AB/54/20/PL

6 The Old Slipway River Road Arundel BN18 9EY

New second floor Juliet balcony.

Second Floor Plan + Elevations
as Proposed

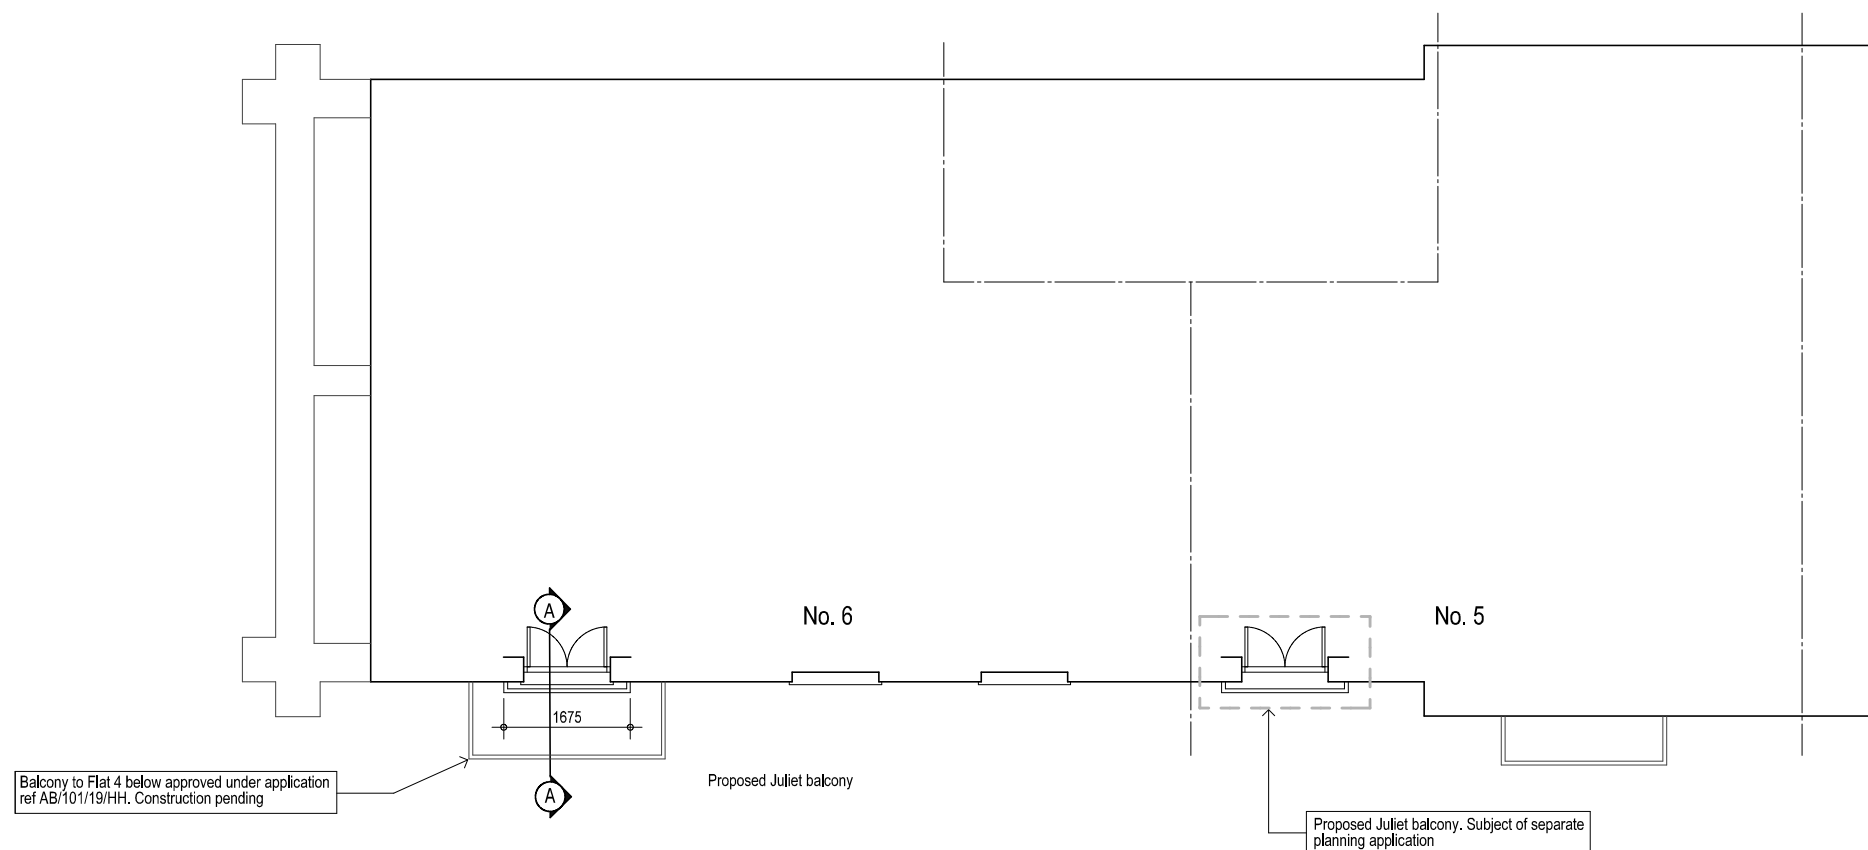
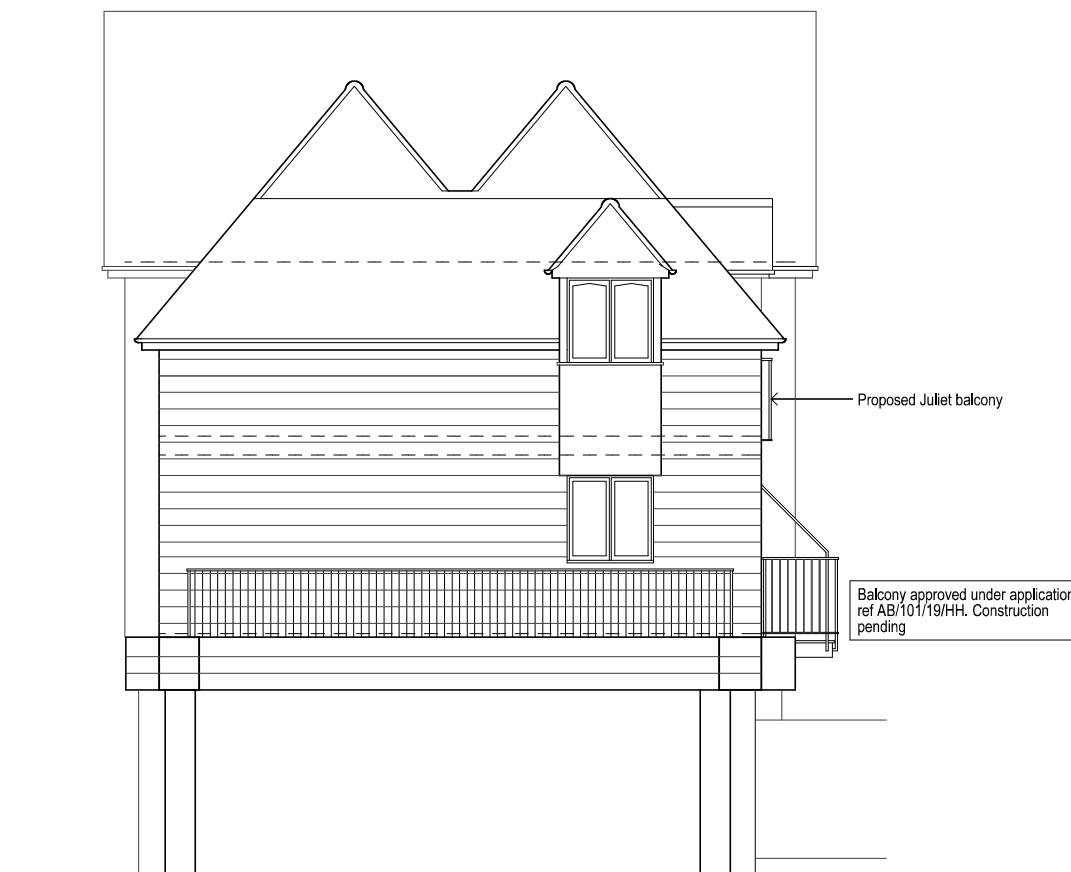
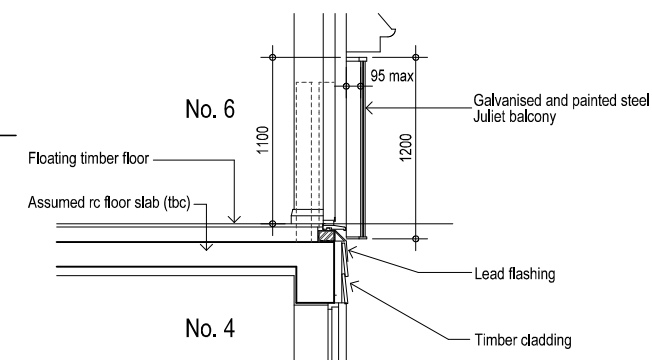
The proposal is to remove an existing south facing window and install inward opening French doors. Further, a galvanised and painted steel Juliet balcony will be fixed to the face of the building. The proposal is considered to be of a scale which will not harm the appearance of the building or the character of the local area. The new French Window should match the existing joinery in terms of appearance, and colour. Likewise, the balcony should also be the same colour as those already present.
